MMO Reference: DCO/2022/00003
Planning Inspectorate Reference: EN010136
Identification Number: 20048964

Planning Act 2008, BP Alternative Energy Investments Ltd, Proposed Morgan Offshore Windfarm Generation Assets Order

Deadline 4 Summary

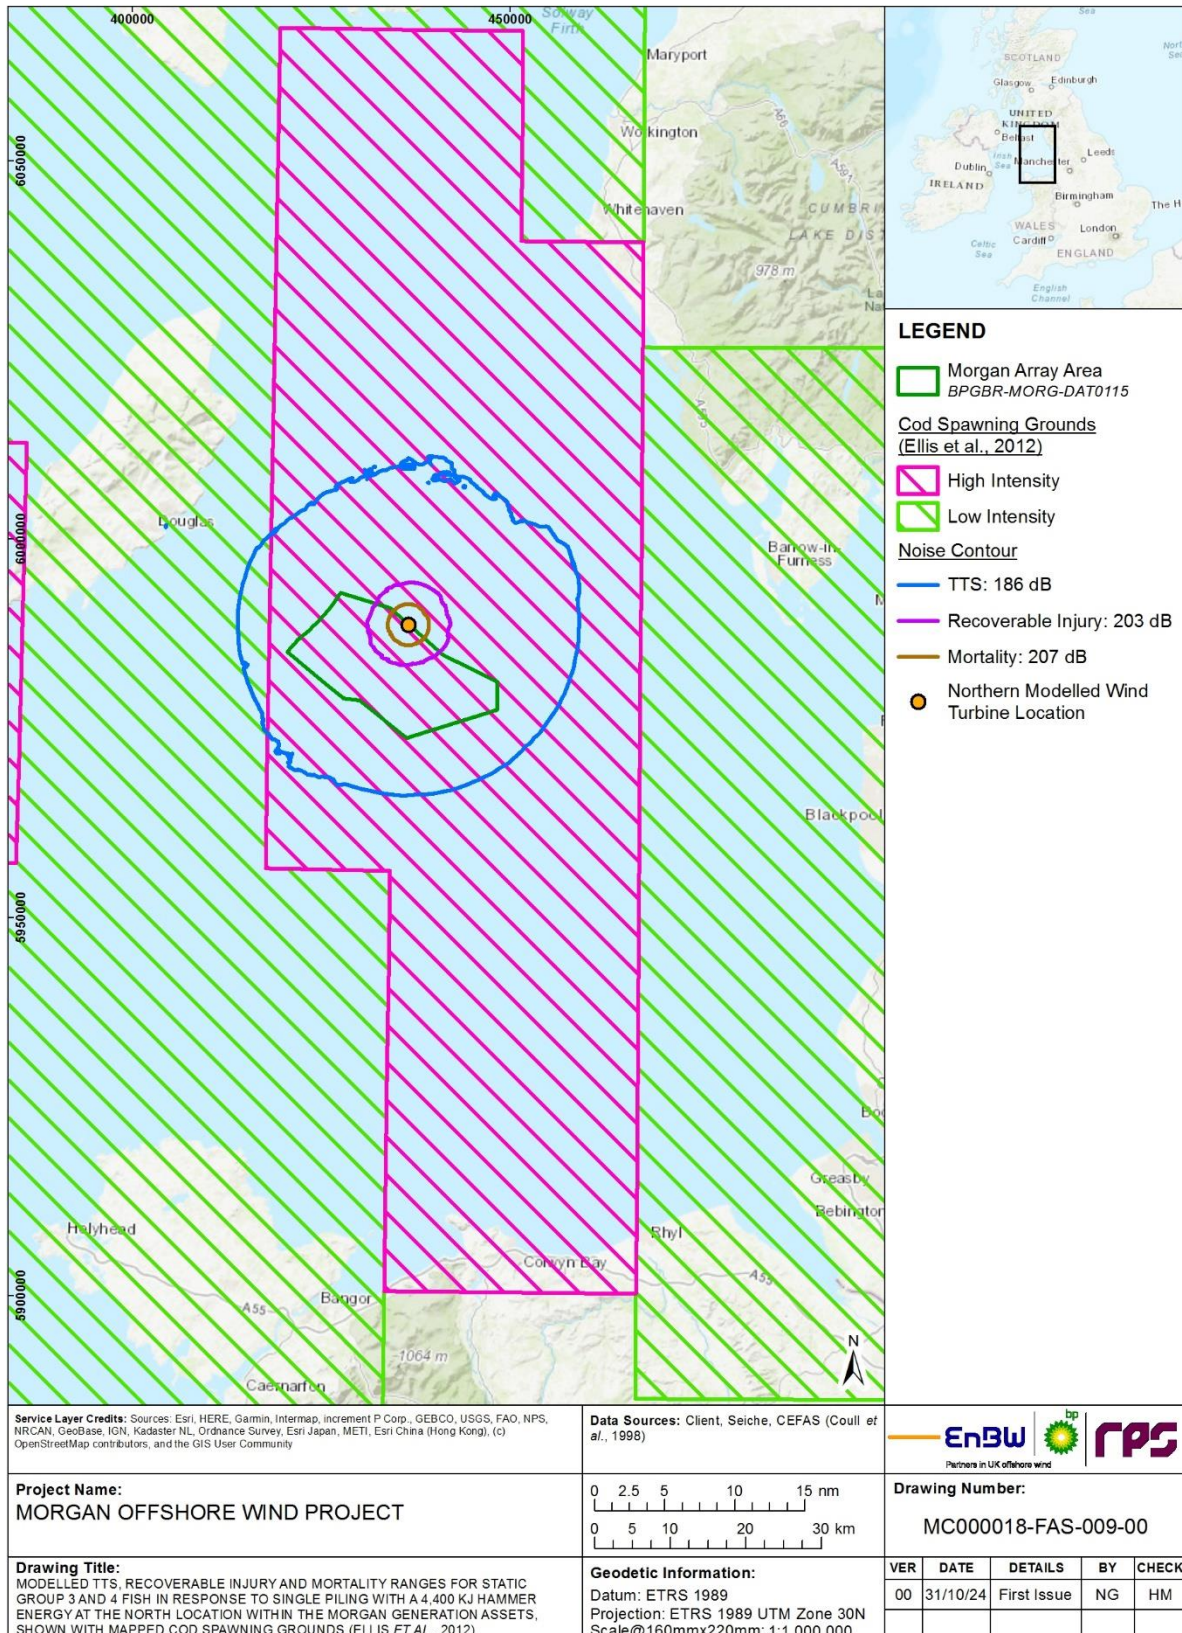
- 5.1. The MMO thanks the Applicant for the submission of Annex 3.1 which contains updated sound modelling, requested by the MMO at Deadline 2, in response to issues surround Underwater Noise.
- 5.2. The MMO remains in disagreement with the Applicant's conclusion for the project alone assessment of underwater sound impacts to cod. The updated modelling

provided in Figure 1.3 of Annex 1.3 shows that physiological TTS effects in cod extend over much of the cod high intensity spawning ground surrounding the Morgan OWF site. The MMO considers that impacts to cod from UWN are significant for the project alone and for the project cumulatively with other projects.

- 5.3. The provision of this updated modelling does not change the MMO's position on the Underwater Sound Management Strategy (UWSMS) or the MMO's recommendation that seasonal piling restrictions during the cod and herring spawning seasons should be conditioned onto the DML for this project until such time that noise reduction strategies are provided and reviewed as part of the UWSMS.
